Our Reference: SYD18/01322/23

Departments Reference: SSD 9522

RESPONSE TO SUBMISSIONS ADDENDUM - KEMPS CREEK WAREHOUSE, LOGISTICS AND INDUSTRIAL FACILITIES HUB (SSD 9522)

Swept Path Analysis – Prepared by MU Group

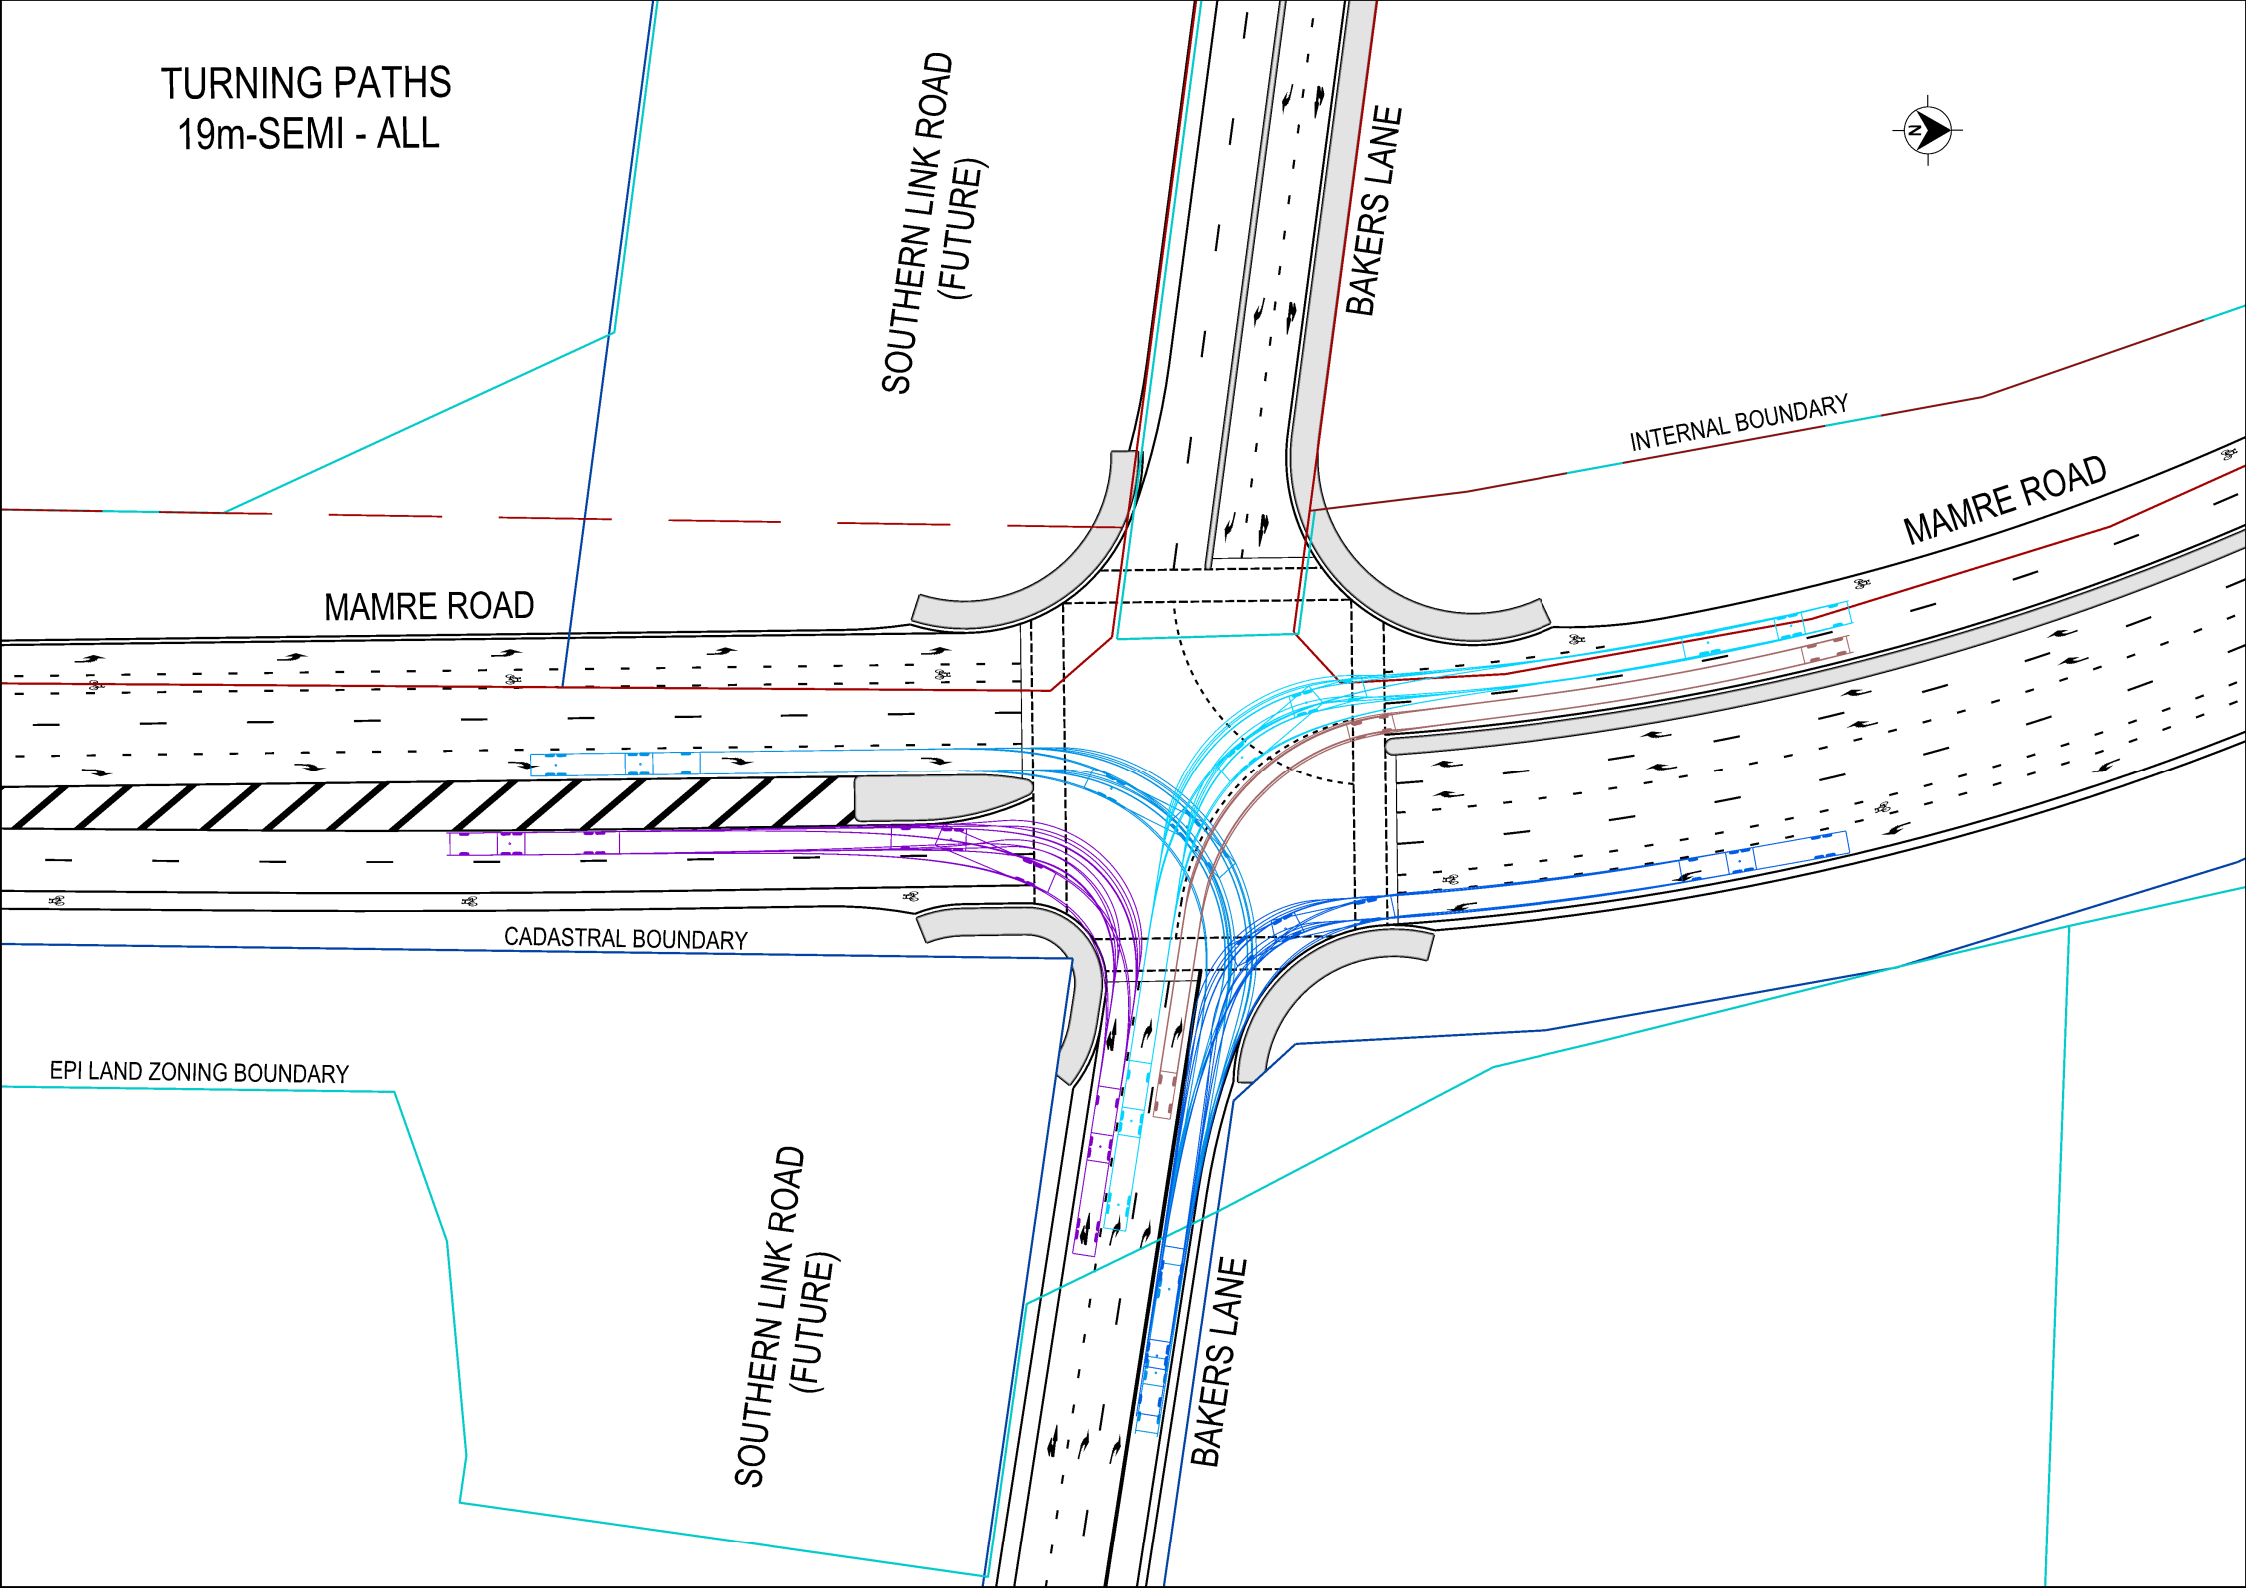
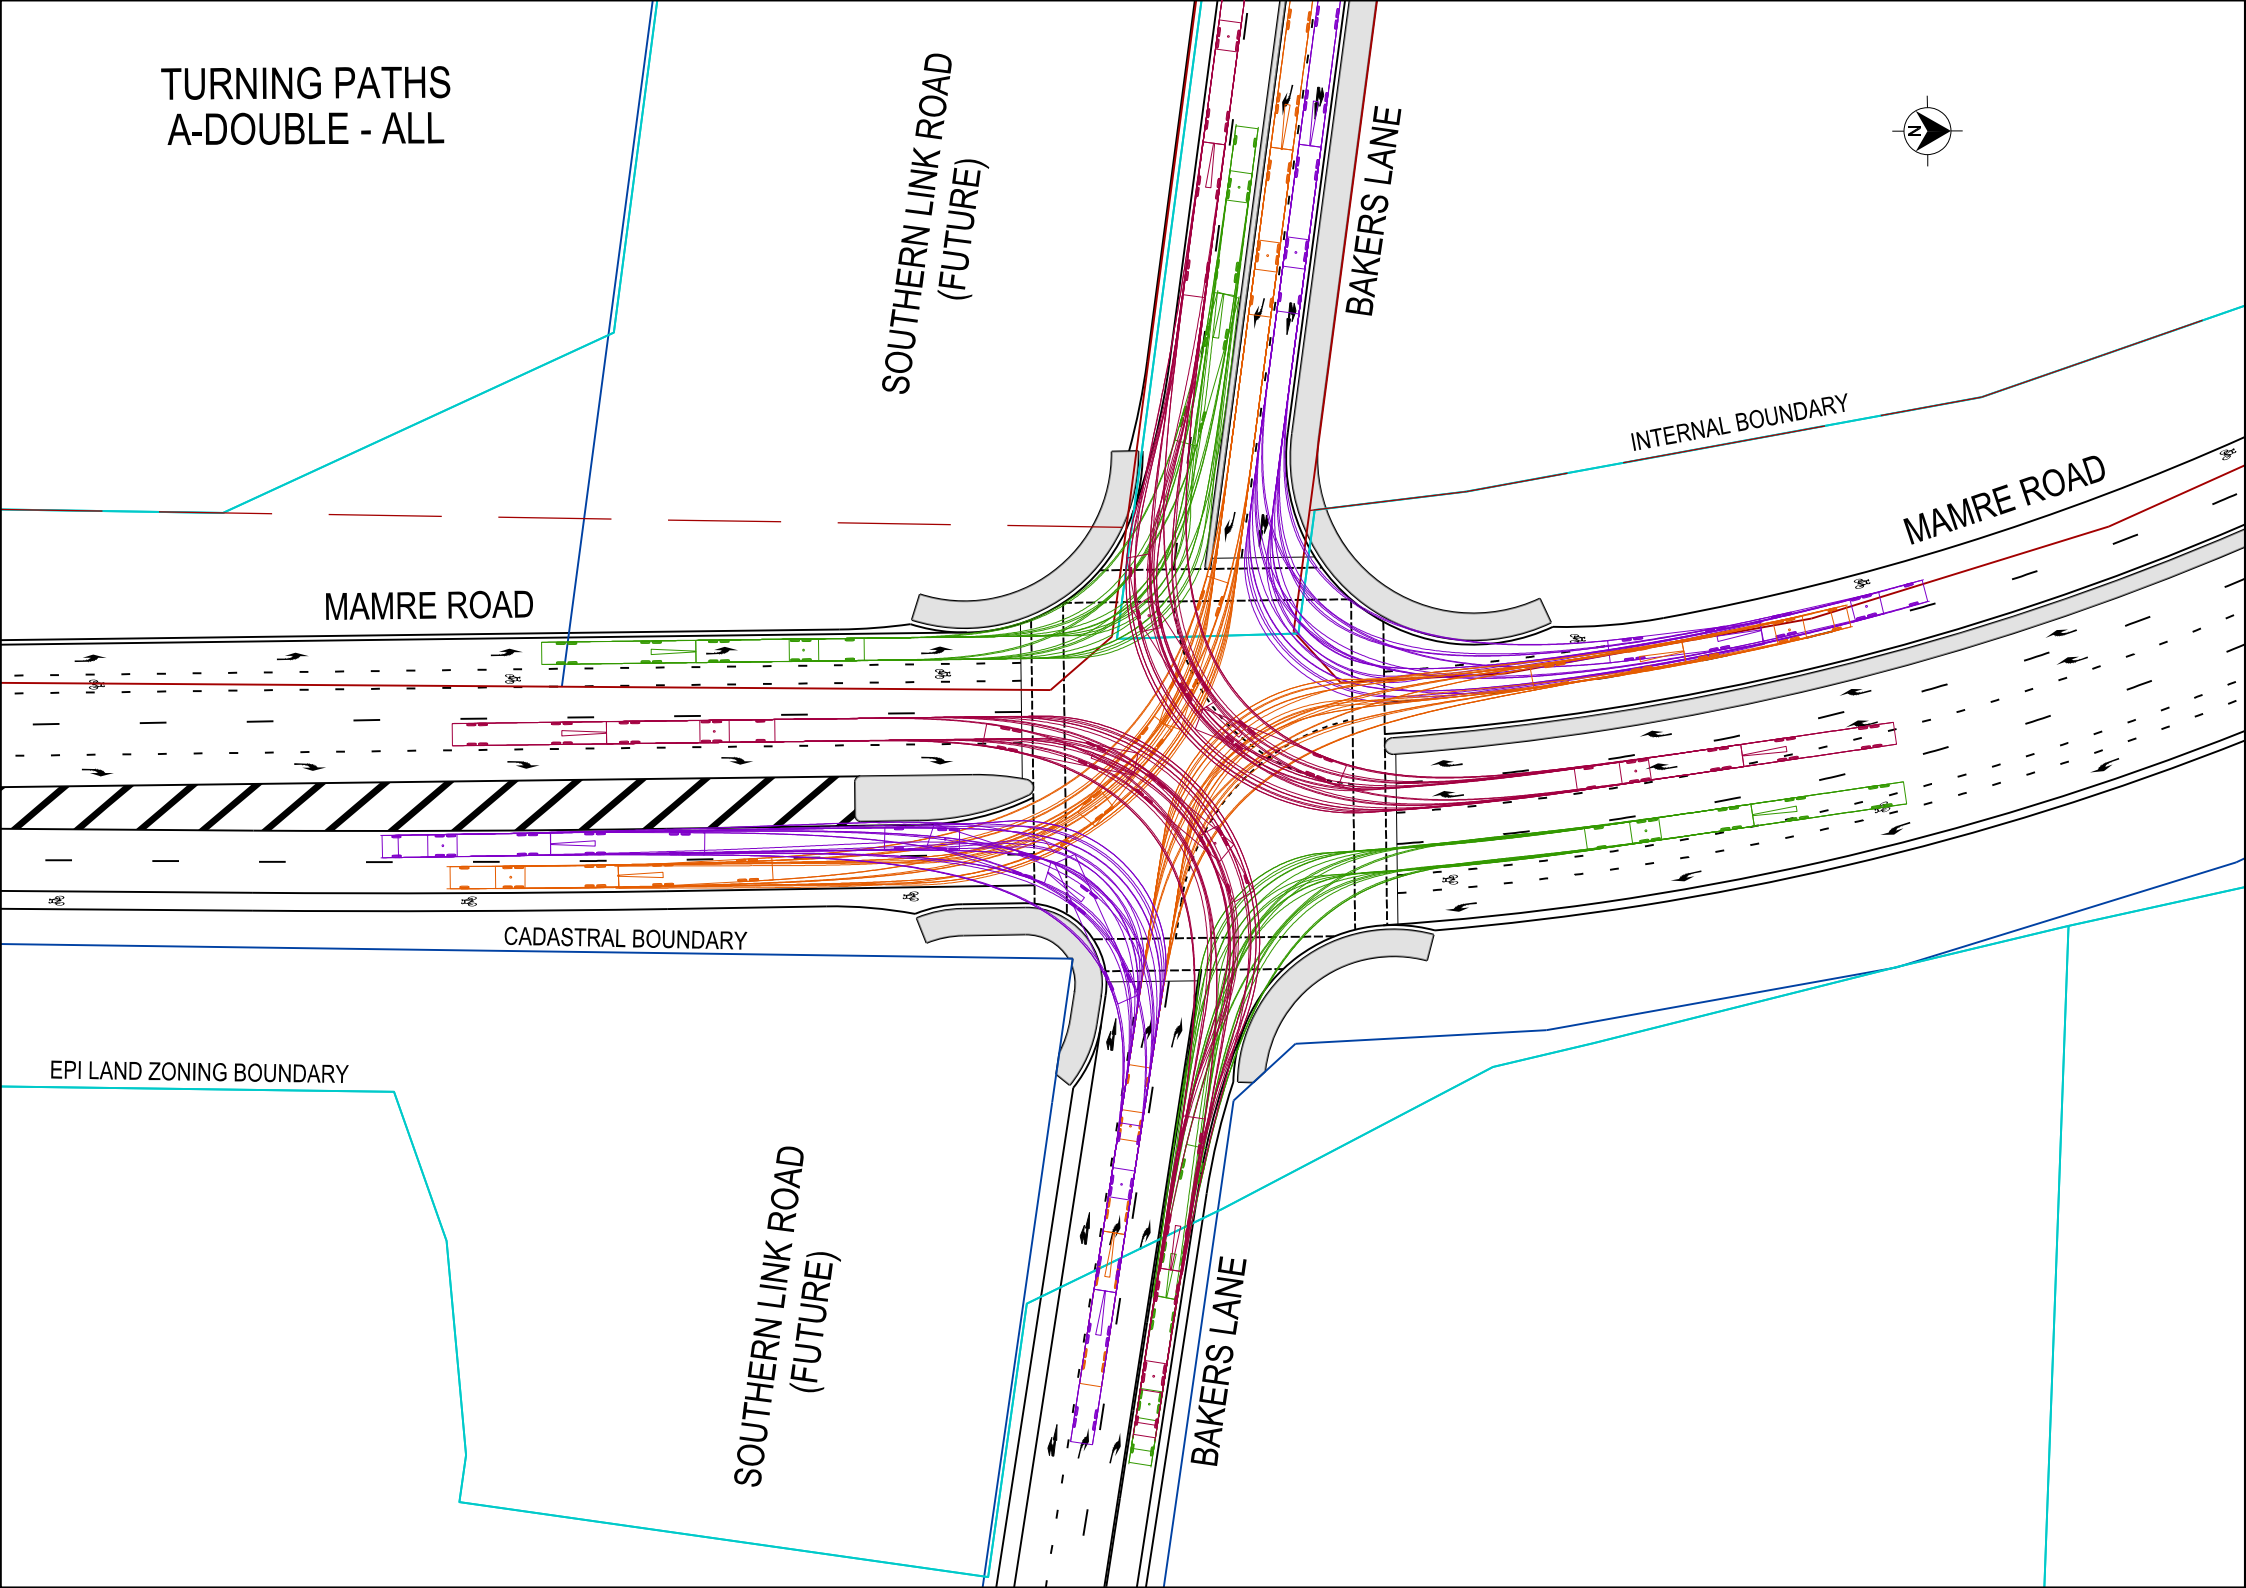
- i. Concept (or Strategic) Civil plans
 - ii. Draft Traffic Control Signal (TCS) plans
 - iii. Swept Path Plans
 - iv. Traffic Report – information is to be consistent with the actual proposed design
 - v. Warrant Assessment
 - vi. Land Owners Consent (If required)
2. In addition to the above point TfNSW provides the following high level design comment which is required to be incorporated into the design prior to further review of the intersection of Mamre Road/Bakers Lane. The swept path diagram provided indicates that the left turn into the Bakers Lane (east) is restricted to a 19 metre semi-trailer. As this is a new signalised intersection within an industrial land development TfNSW requires the whole intersection to be designed for a 26 metre B-double vehicle. Consideration should also be made in the design to accommodate for a PBS 3 Access Class A (36.5 metre) heavy vehicle.
